DECISION DELEGATED TO DEVELOPMENT MANAGER

Application No: H14-0283-20 **Applicant:** Mr & Mrs A Smith
Proposal: Residential Development - erection of one dwelling
Location: The Sycamores Glenside South West Pinchbeck
Terminal Date: 1st July 2020

LOCATION PLAN
BLOCK PLAN - ROPOSED
INDICATIVE LAYOUT.

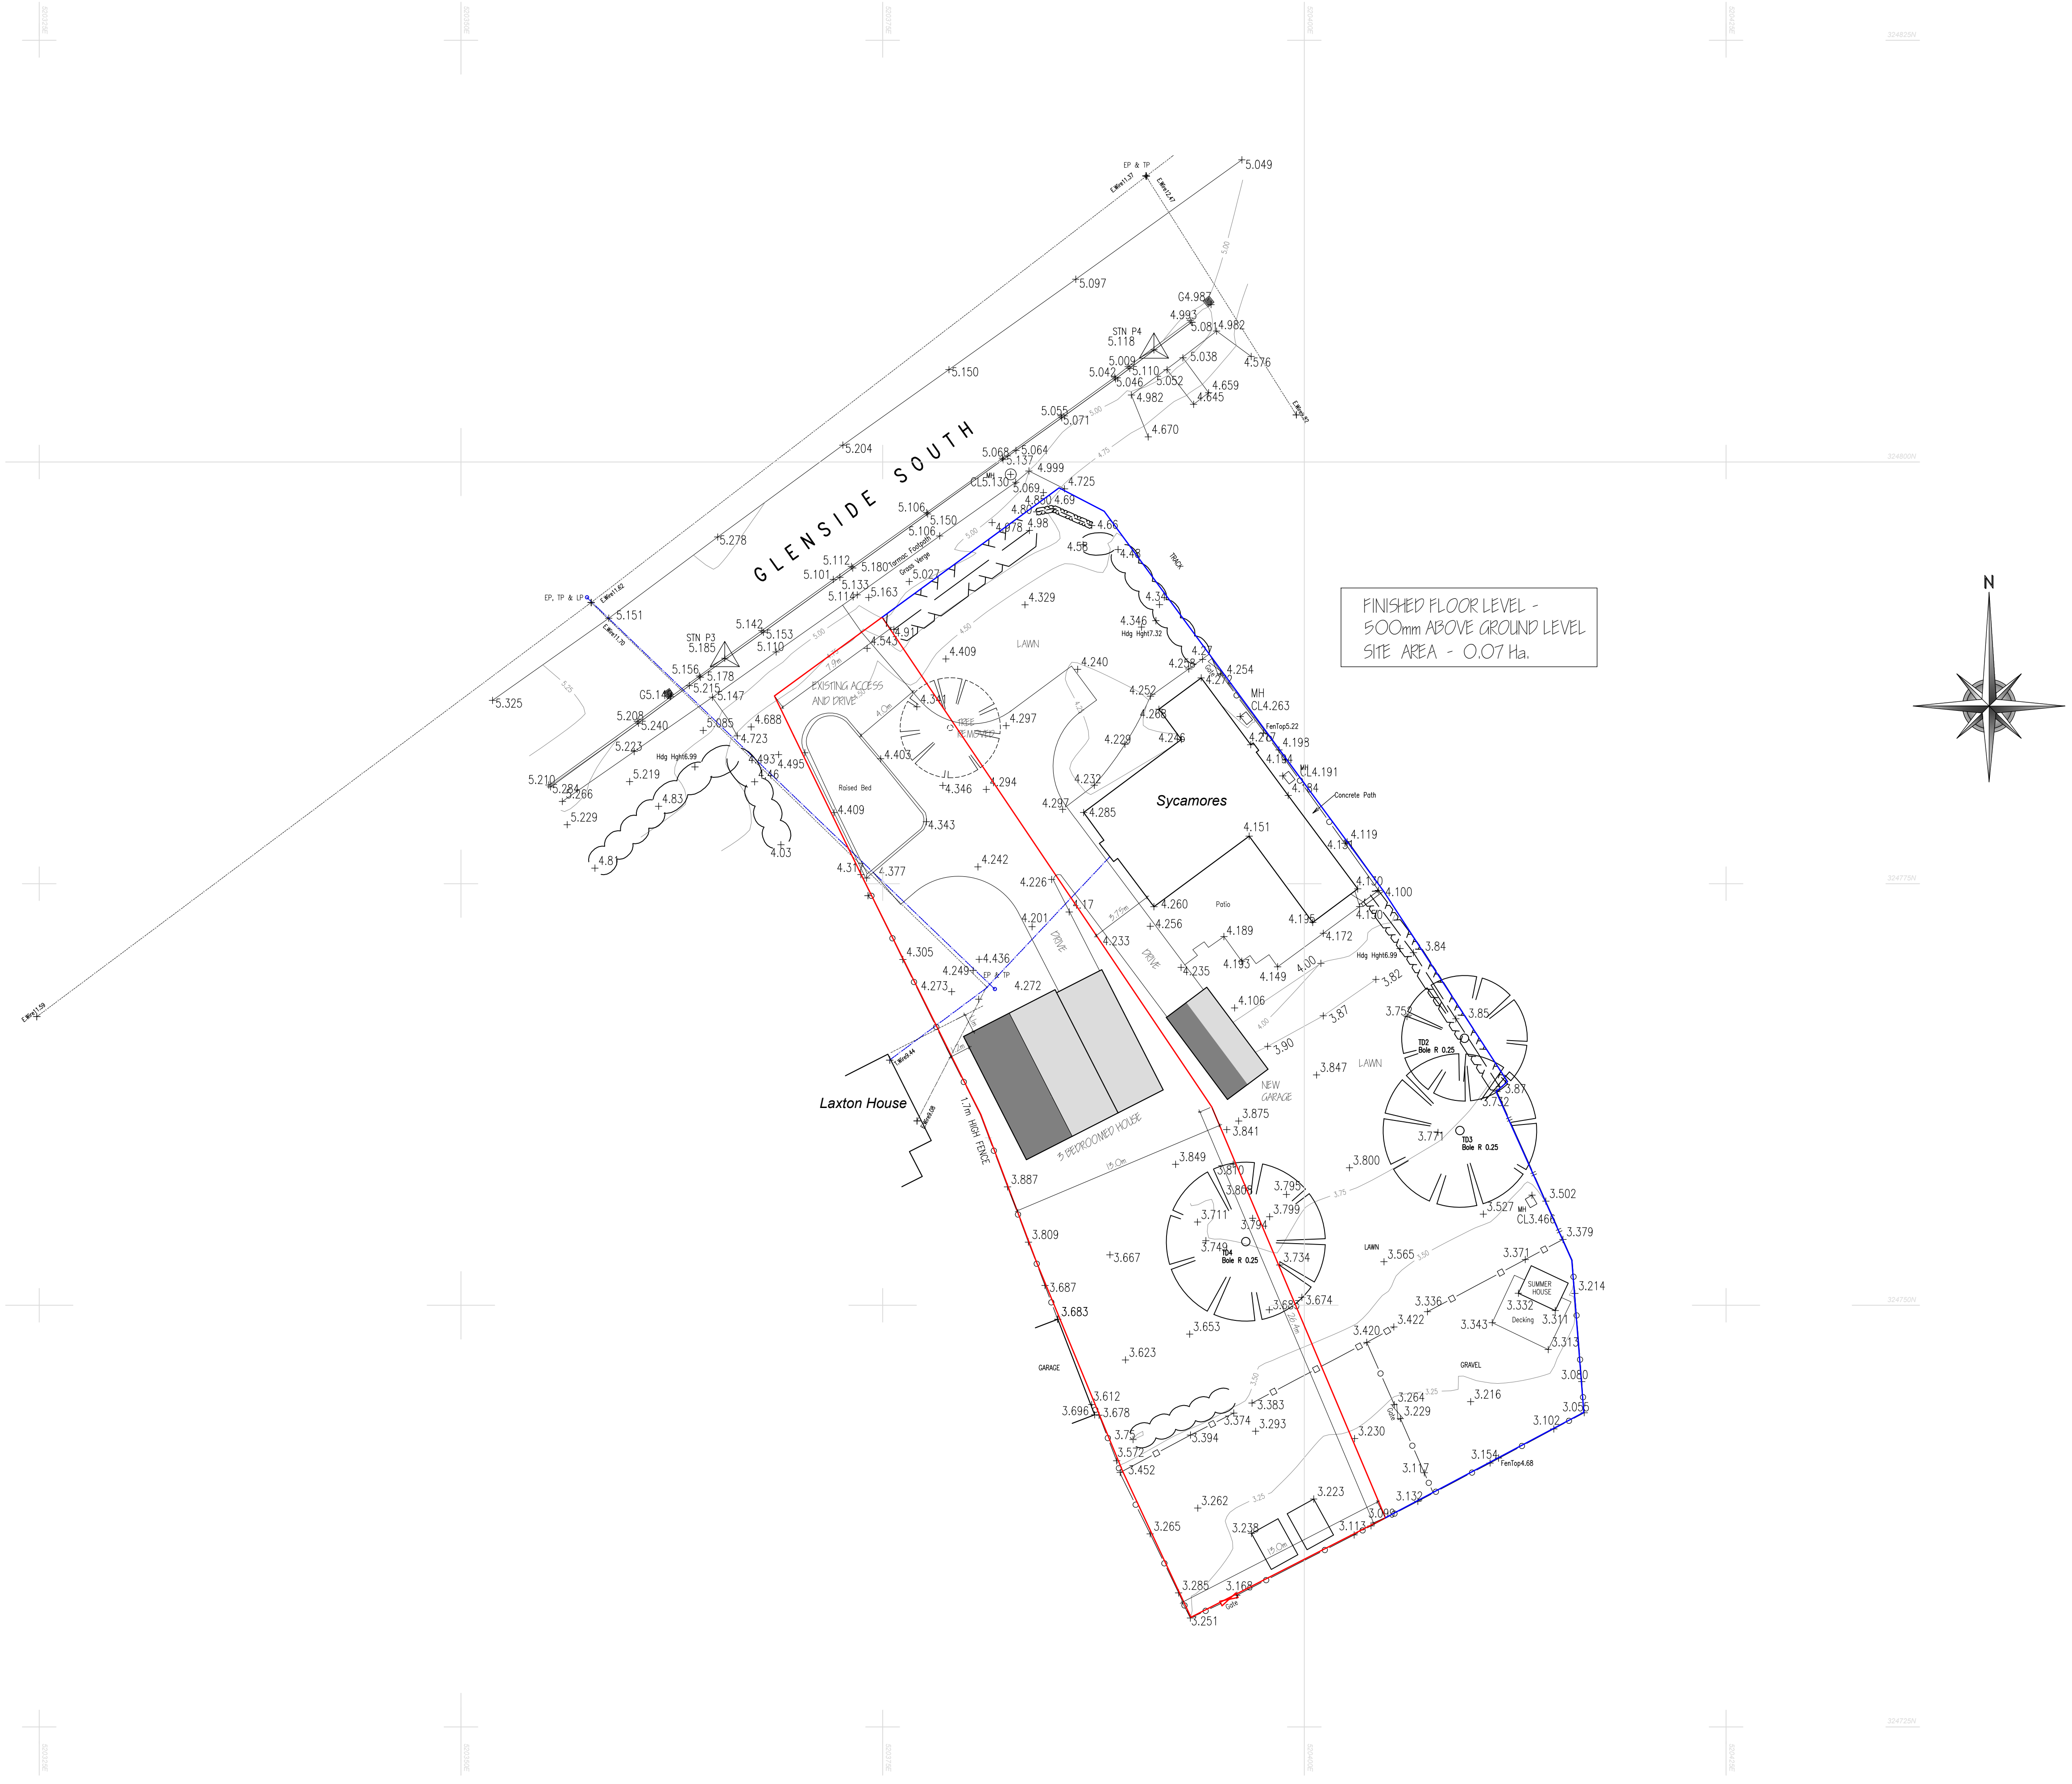
The indicative layout plan shows a paired access from Glenside South which splits to two separate driveways for the existing and proposed dwelling. It would appear that sufficient room can be provided to enable a motor vehicle to turn within the site so that it can enter and leave the highway in a forward gear. Further details shall be submitted at a later stage though.

The indicative block plan submitted with the application shows separation distances of approximately 4.74 and 4.50 metres between the proposed dwelling and the opposing elevations of neighbouring properties to the west and east respectively. At such a distance, it is not considered that the development would create any harm upon the amenity standards of the residents in adjacent properties in terms of being overbearing in nature or resulting in a material loss of light.

On the account of the close proximity of the proposed dwelling with the neighbouring Laxton House, details of fenestration on the west elevation should be submitted and carefully considered at a reserved matters stage.

Having regarded to the considerations above, it is confirmed that both sequential and exception tests are satisfactorily passed and the proposed scheme in its outline form is considered to be acceptable in terms of flood risk. Consequently, it is recommended to grant permission subject to a condition to comply with the FRA recommendation of erecting a two storey dwelling with finished floor levels set no lower than 4.7 AOD, 500mm above existing ground levels.
